COUNTY COUNCIL'S RESPONSE TO CONSULTATION ON THE FOLLOWING DEVELOPMENT PROPOSAL

Application no:19/01036/HYBRID-2

Proposal: Development of a new Local Centre comprising Retail, Commercial and Community floorspace (flexible Use Class A1/A2/A3/B1/D1), and 38 residential units (use class C3) with associated access, servicing, landscaping and parking

Location: Bicester Eco Town Exemplar Site Phase 2 Charlotte Avenue Bicester

CHARLOTTE AVENUE

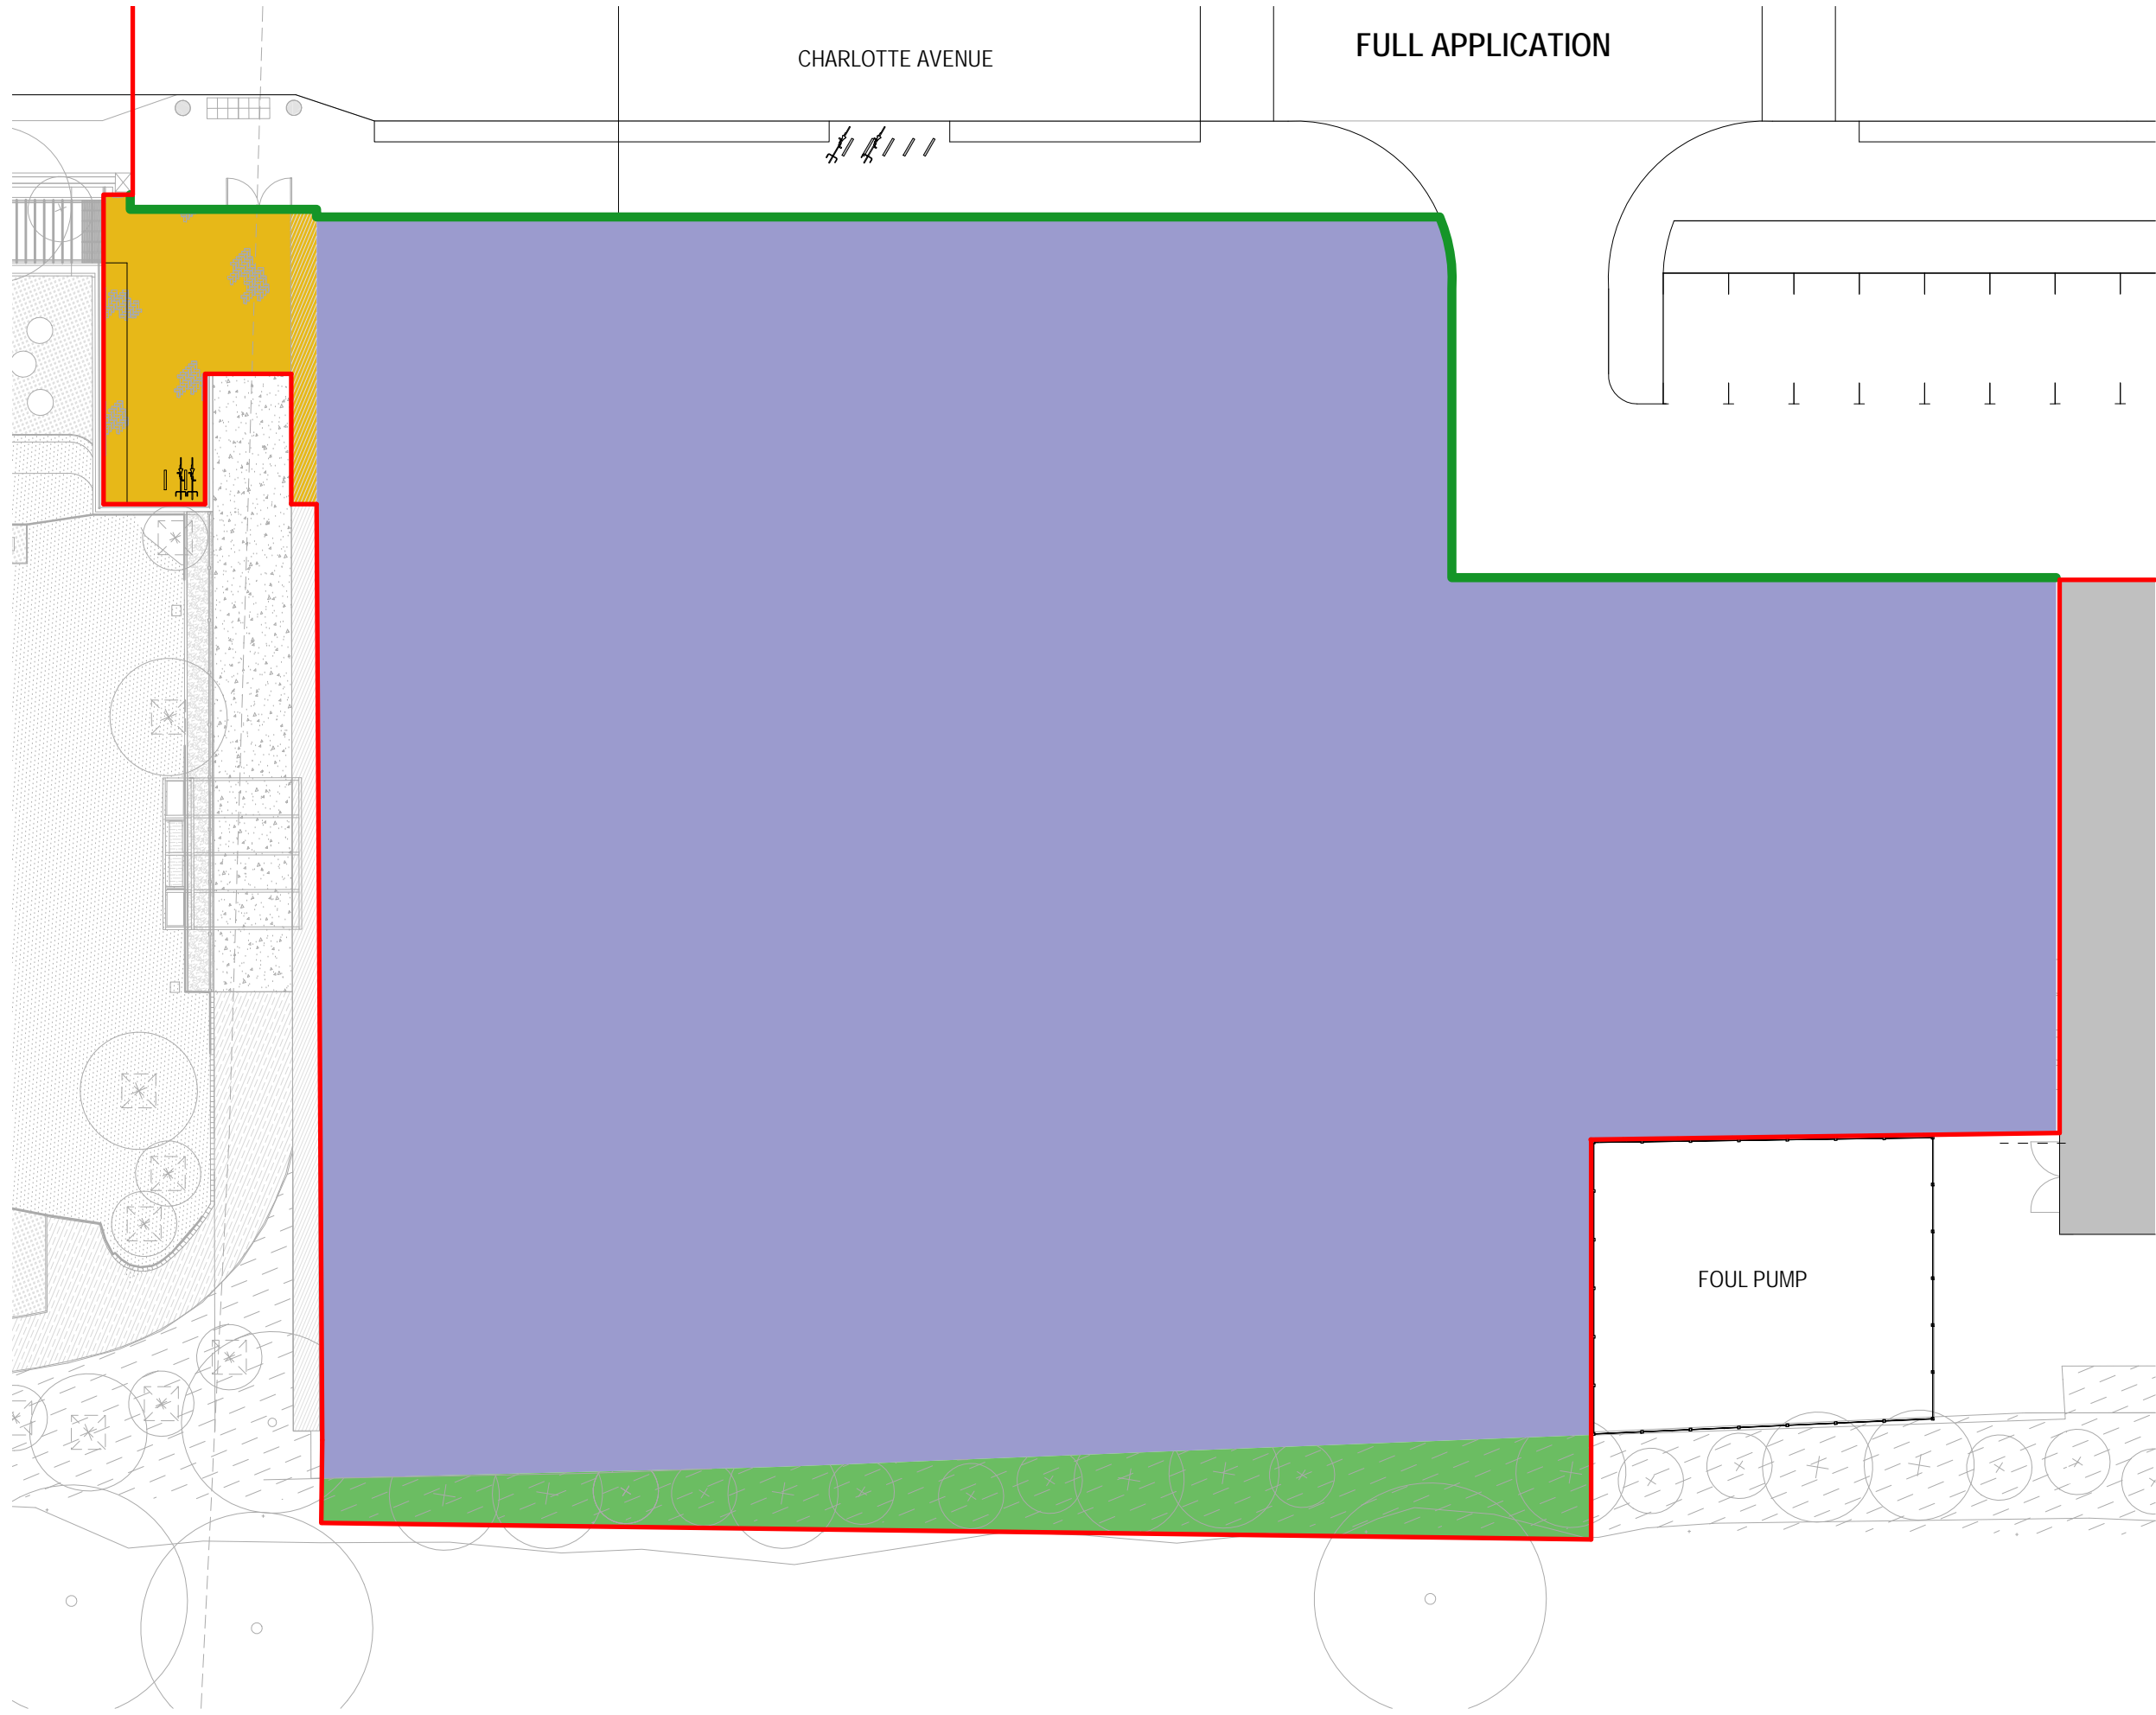
Vehicle Tracking – Tracking diagrams have been provided for the site layout showing that an 11.7m refuse vehicle would be able to manoeuvre in and out of the site. However, I do not believe that the refuse vehicle can safely get to within the recommended distance to service the bin storage located to the top left corner of the site.

To accomplish the refuse collection task, the refuse wagon needs to utilise land (outside of the red application line) north of the Eco Business Centre in order to reverse towards the bin storage area (see snippet below). Similarly, I believe egress shall be harder to achieve except by blindly reversing back onto Charlotte Avenue, a manoeuvre deemed to be unsafe for all users.

A confirmatory letter of agreement between the developer of this site and the land owner of the Eco Business Centre to use this area (outside the site application boundary) in order to achieve such manoeuvres has since been provided. Without this perpetual agreement, refuse and service deliveries to the local centre would be impossible.
